**SOIL, GEOLOGY, AND GEOLOGIC HAZARD STUDY
THE RETREAT AT TIMBER RIDGE
VOLLMER ROAD AND ARROYA LANE
EL PASO COUNTY, COLORADO**

April 12, 2017

PHASE MAP

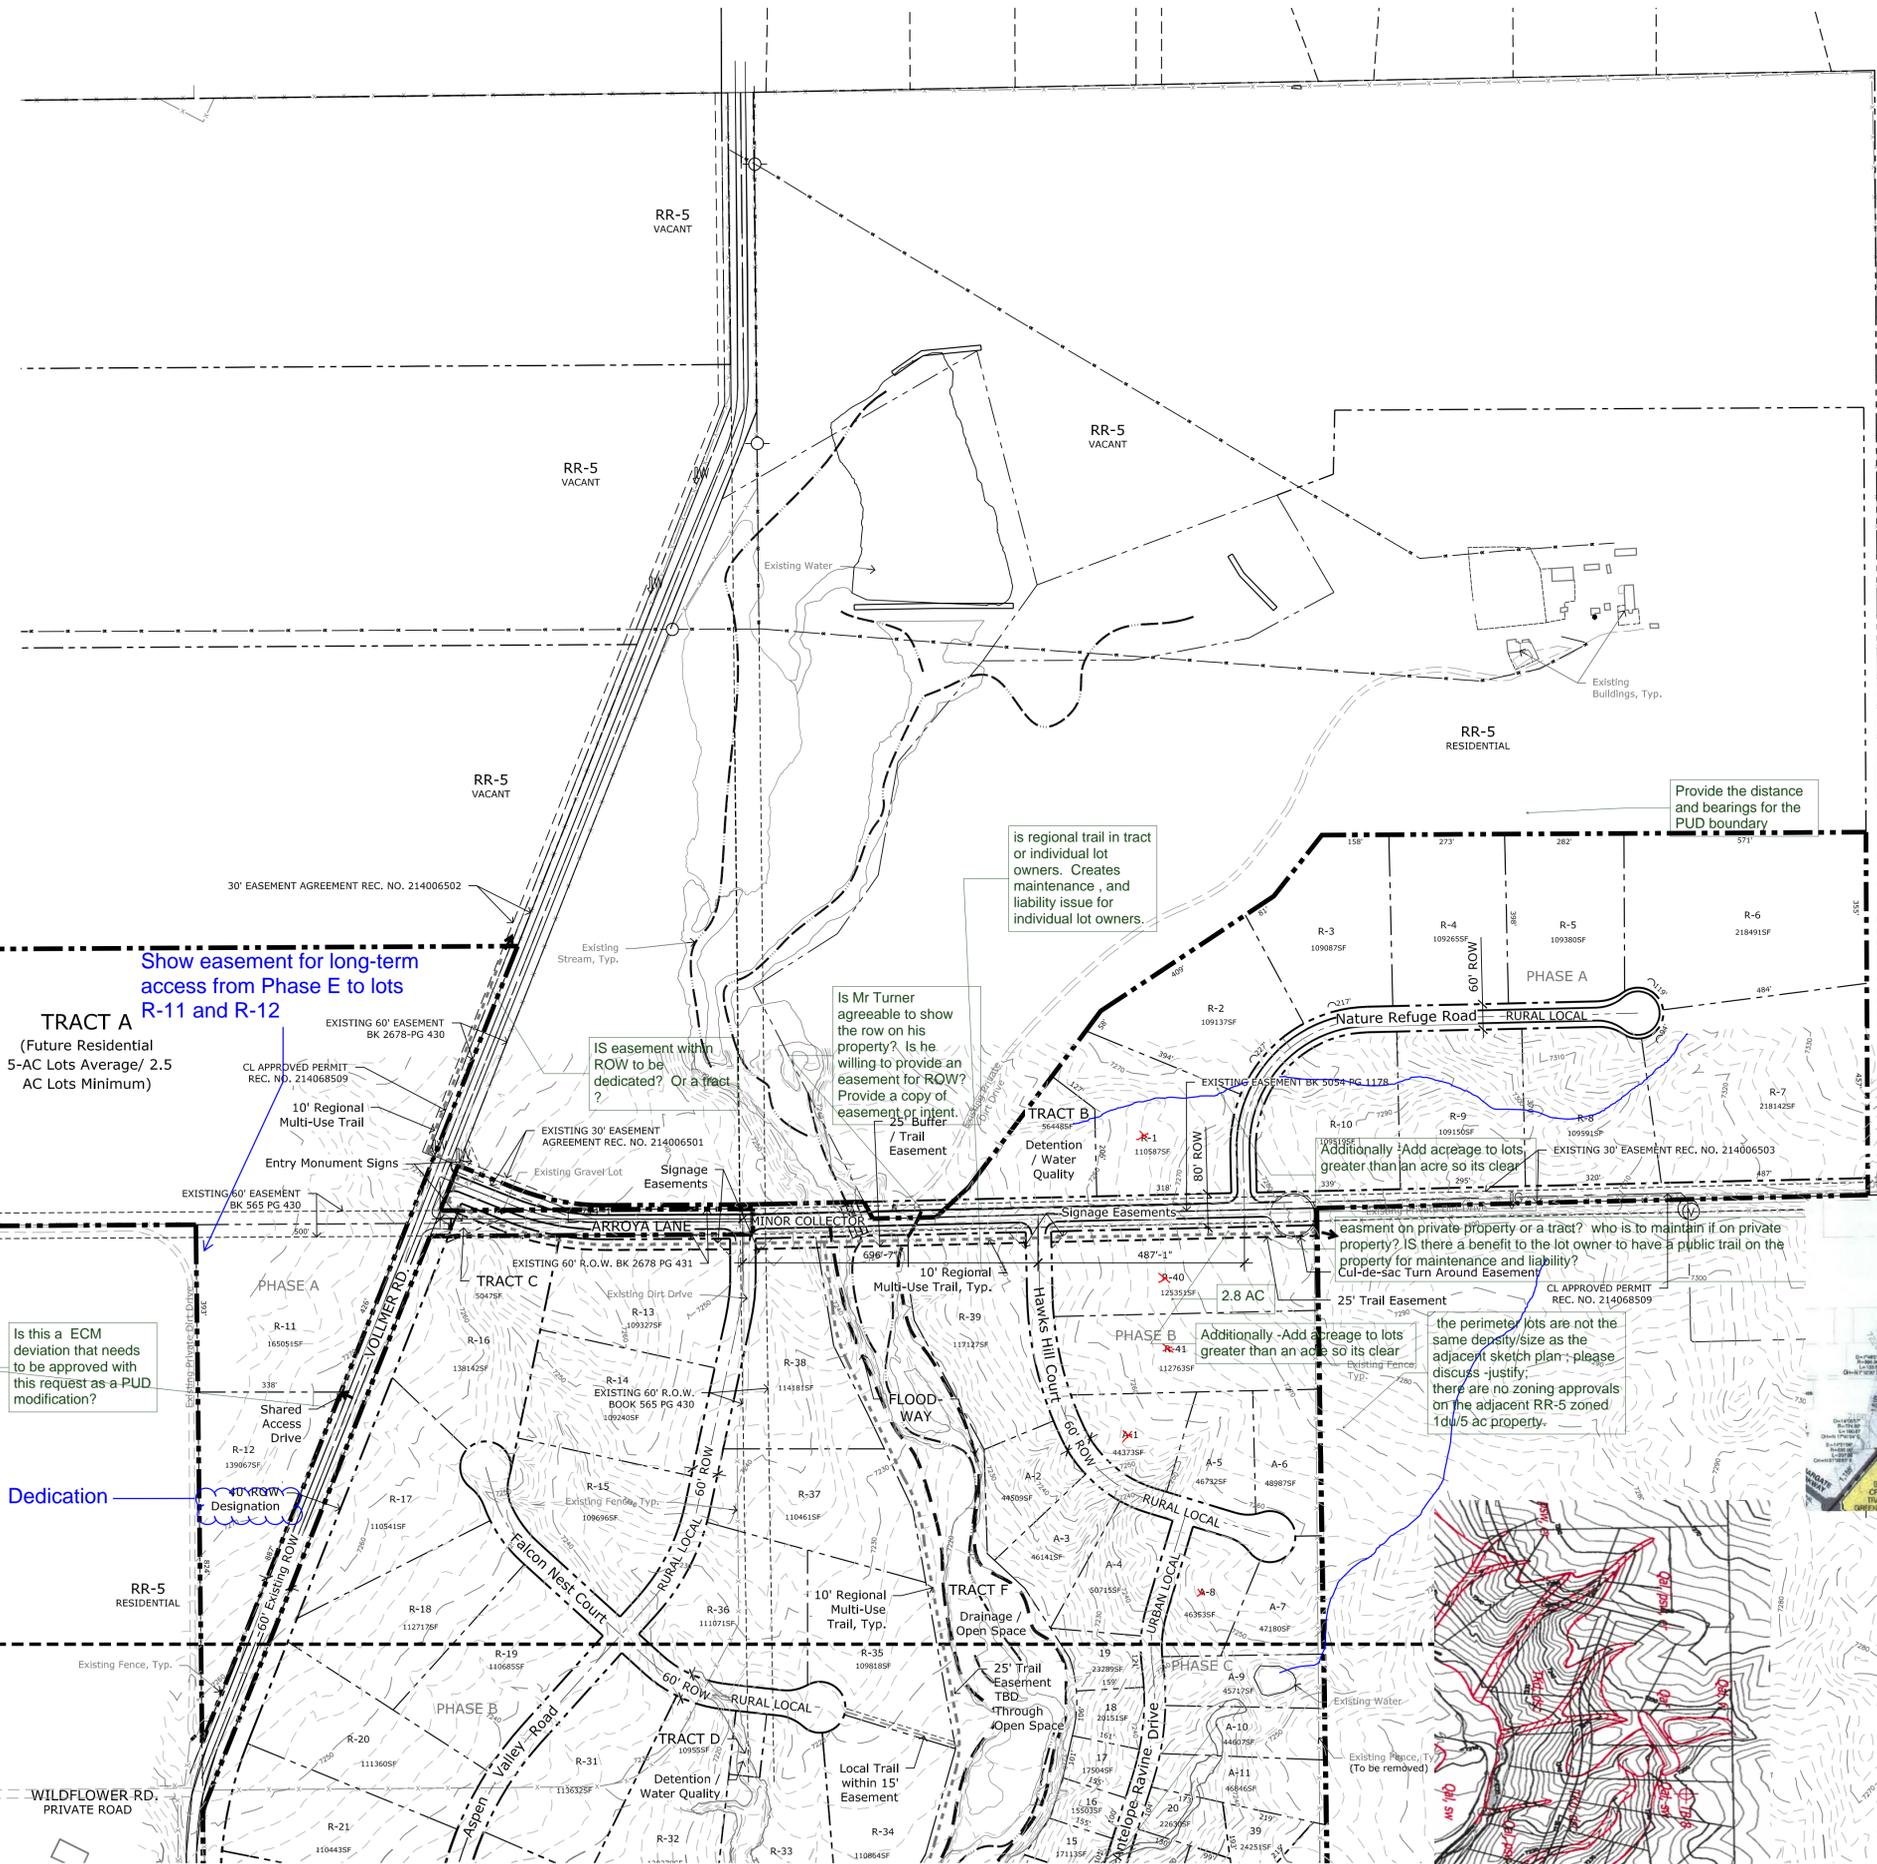
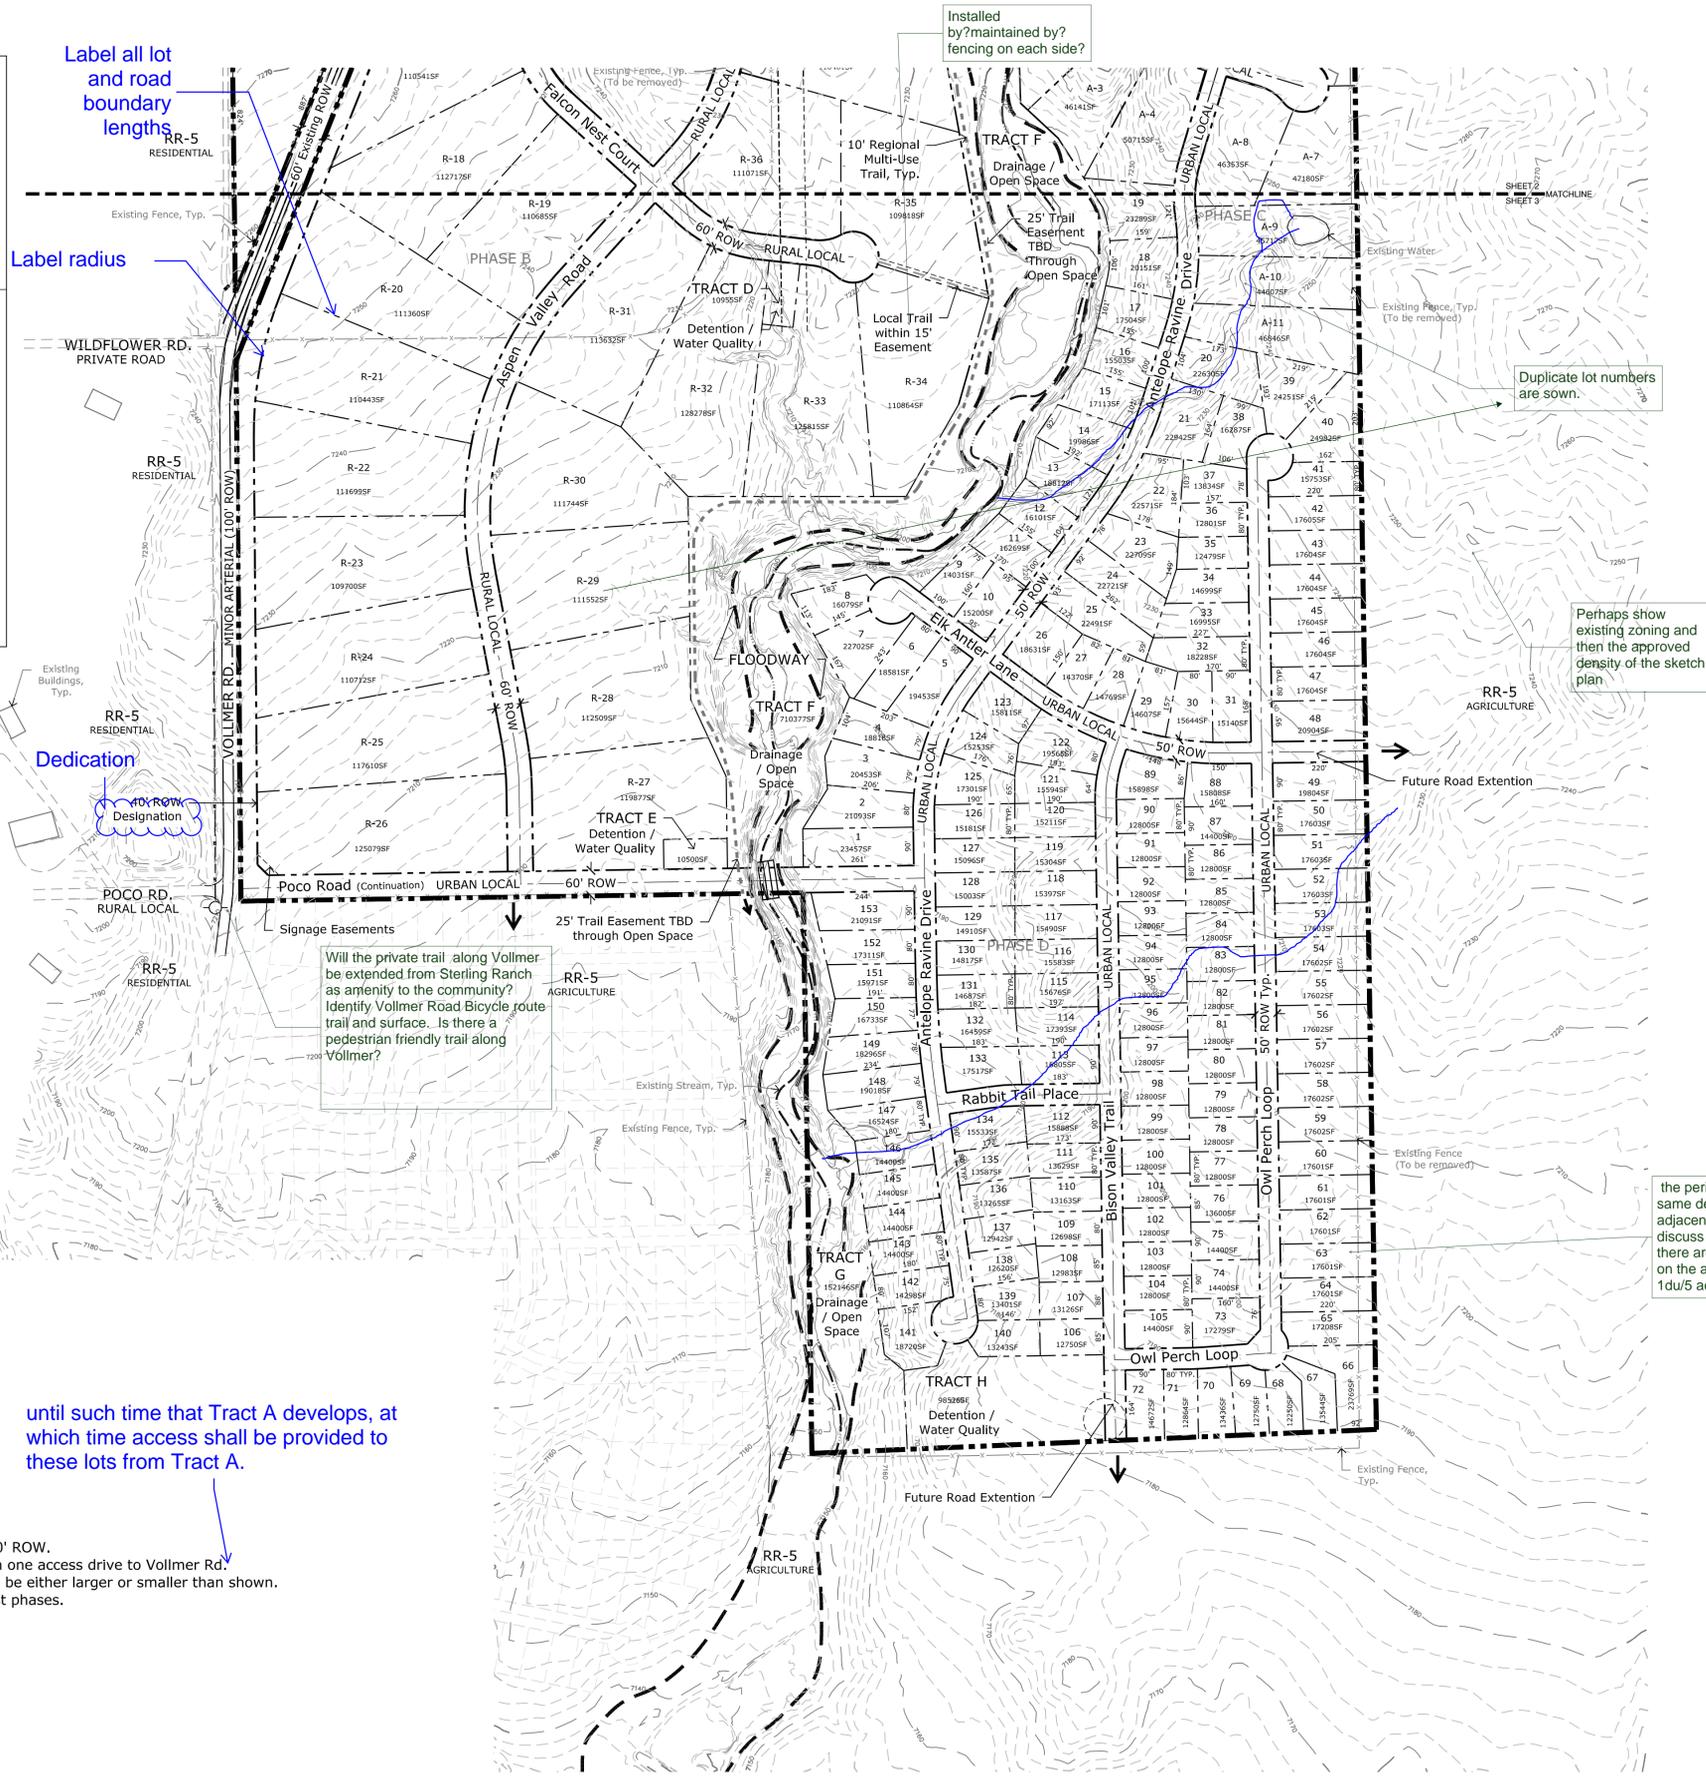
lots less than 2.5 acres are shown in the floodplain which is not allowed per Chapter 8.

Please note these groundwater hazards should be identified on the prelim plan when submitted and noted on the PUD as areas of concern.

Remover lots from floodplain please
